**New Request for Advice – Luddenham Resource Recovery Facility (SSD-10446)  
(Liverpool City) - Environmental Impact Assessment**

## **TAB A – TfNSW Comments – SSD 10446 EIS Luddenham Resource Recovery Facility**

Figure 1.2
ARRC layout

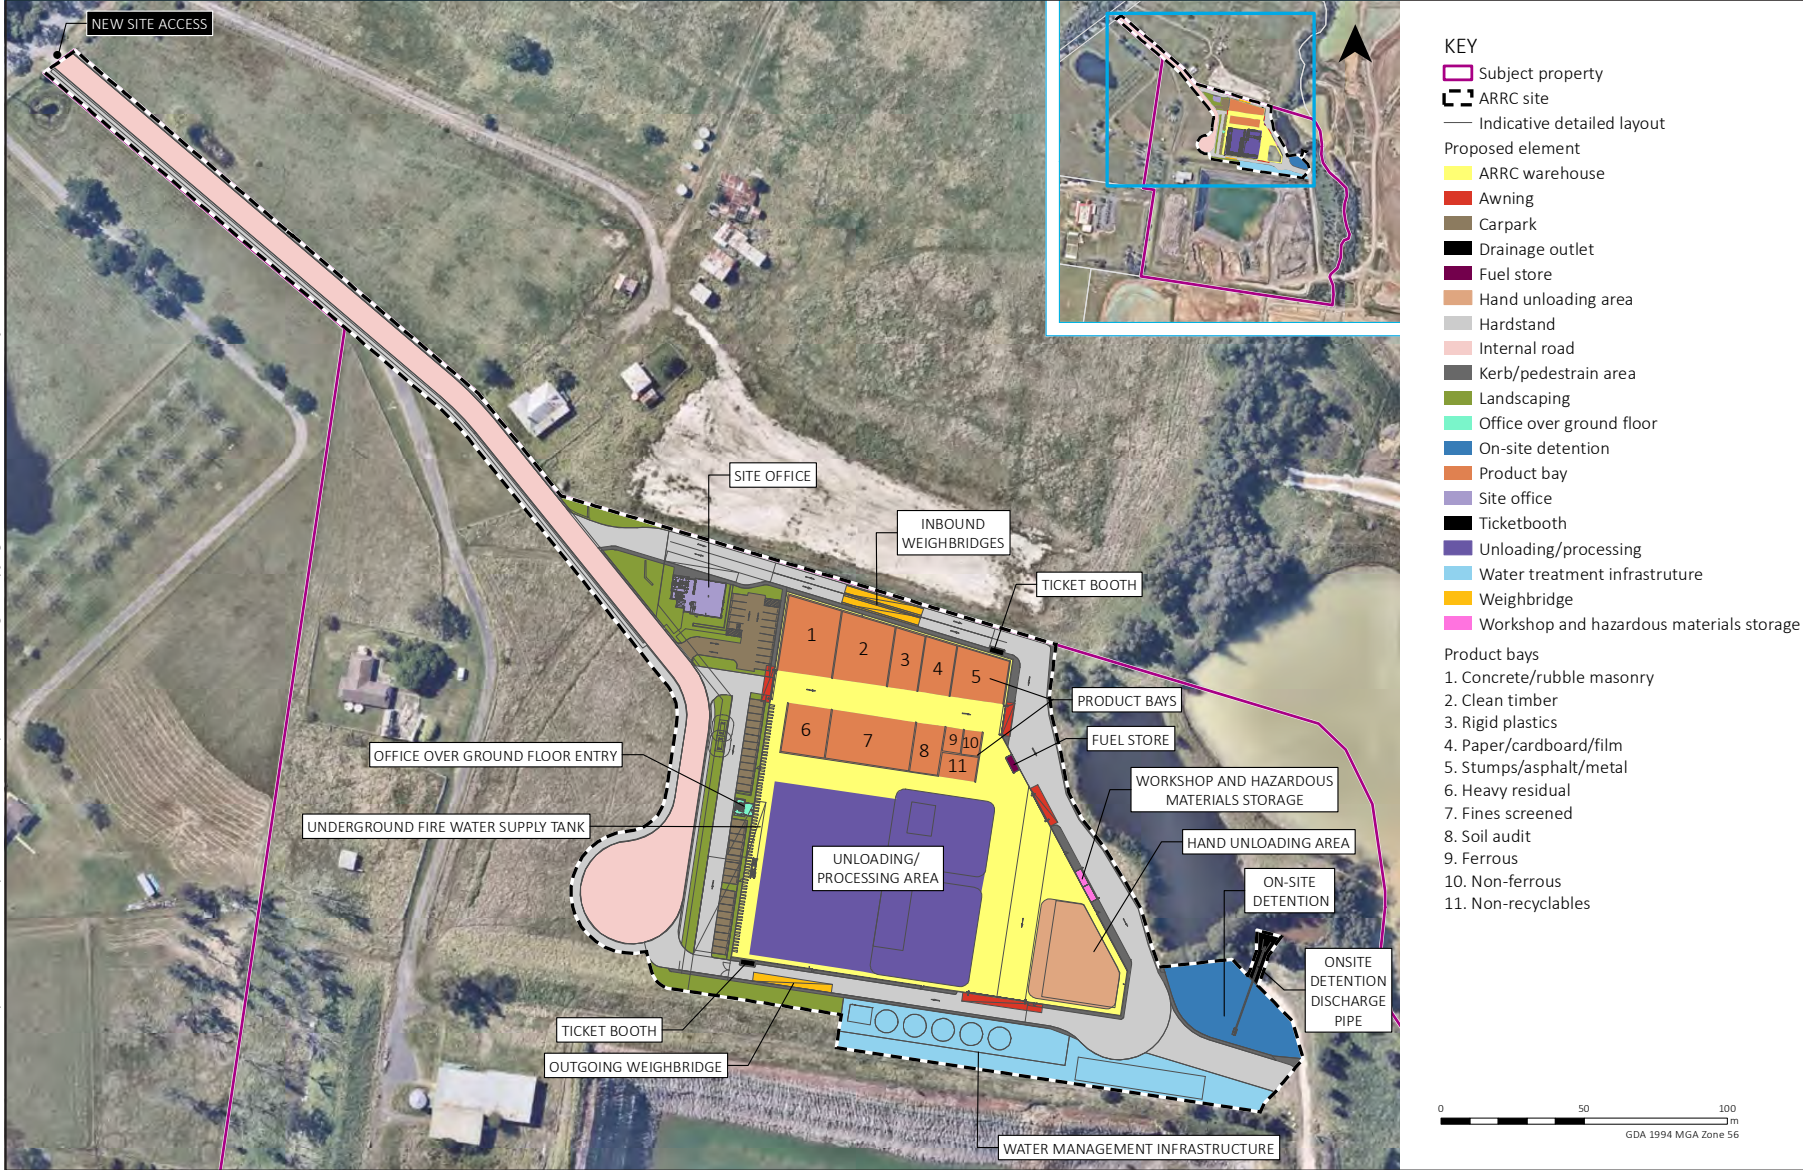
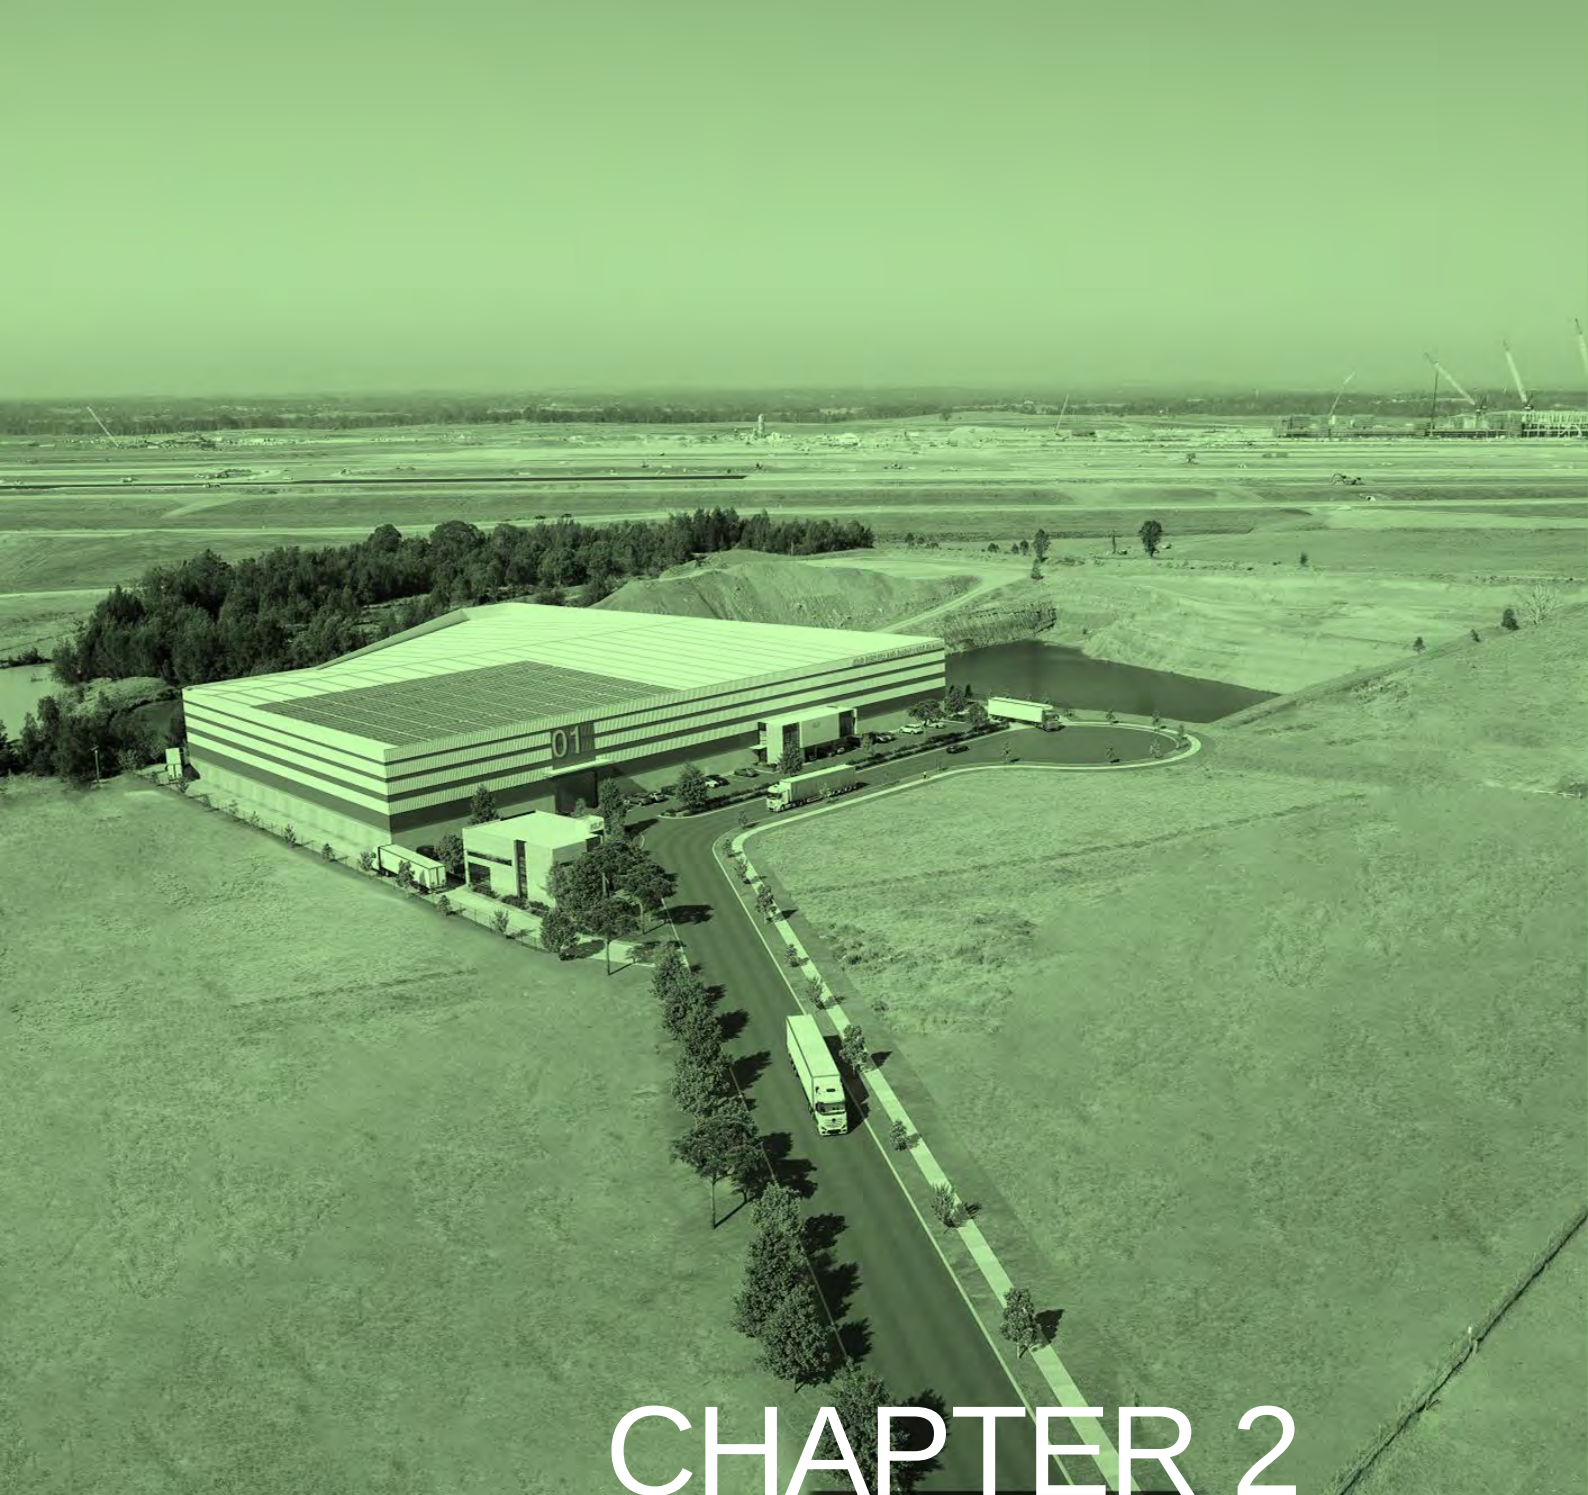
- Transport for NSW has noted some minor discrepancies in the Environmental Impact Statement (EIS), and Traffic Impact Assessment (TIA):
  - Car parking spaces varying between 45 and 47 spaces in the EIS, TIA and site plan;
  - In TIA, 514 vehicles carrying average load of 4.4 tonne, but generating 1,082 trips. The numbers provided also do not add up to 1,368 movements; and
  - Daily heavy vehicles (4.4t vehicles + larger trucks) number provided in the EIS is 585 (page 43), however, in TIA (page 23) the number used is 612.

Truck marshalling area is not identified in the site plan. The TIA states that the access road from Adams Rd to ARRC is over 200m long and should be able to accommodate waste vehicles without queuing on the public road. It is not clear if this area will also be used for heavy vehicle staging/queuing. If so, then the proponent should consider upgrading the access road wide enough to accommodate parked heavy vehicles as well as incoming and outgoing heavy vehicles.

It is requested the proponent clarify the above discrepancies, and take into consideration all the following comments when updating the TIA modelling and required improvements to support the development.

It is requested the updated TIA demonstrate the ability of the access road to accommodate waste vehicles without queueing on the public road, and if the access road will be used for staging/queuing heavy vehicles, the internal road design be able to accommodate a heavy vehicle of Performance Based Standards (PBS) Level 2B. This aligns with the NSW Heavy Vehicle Access Policy Framework.
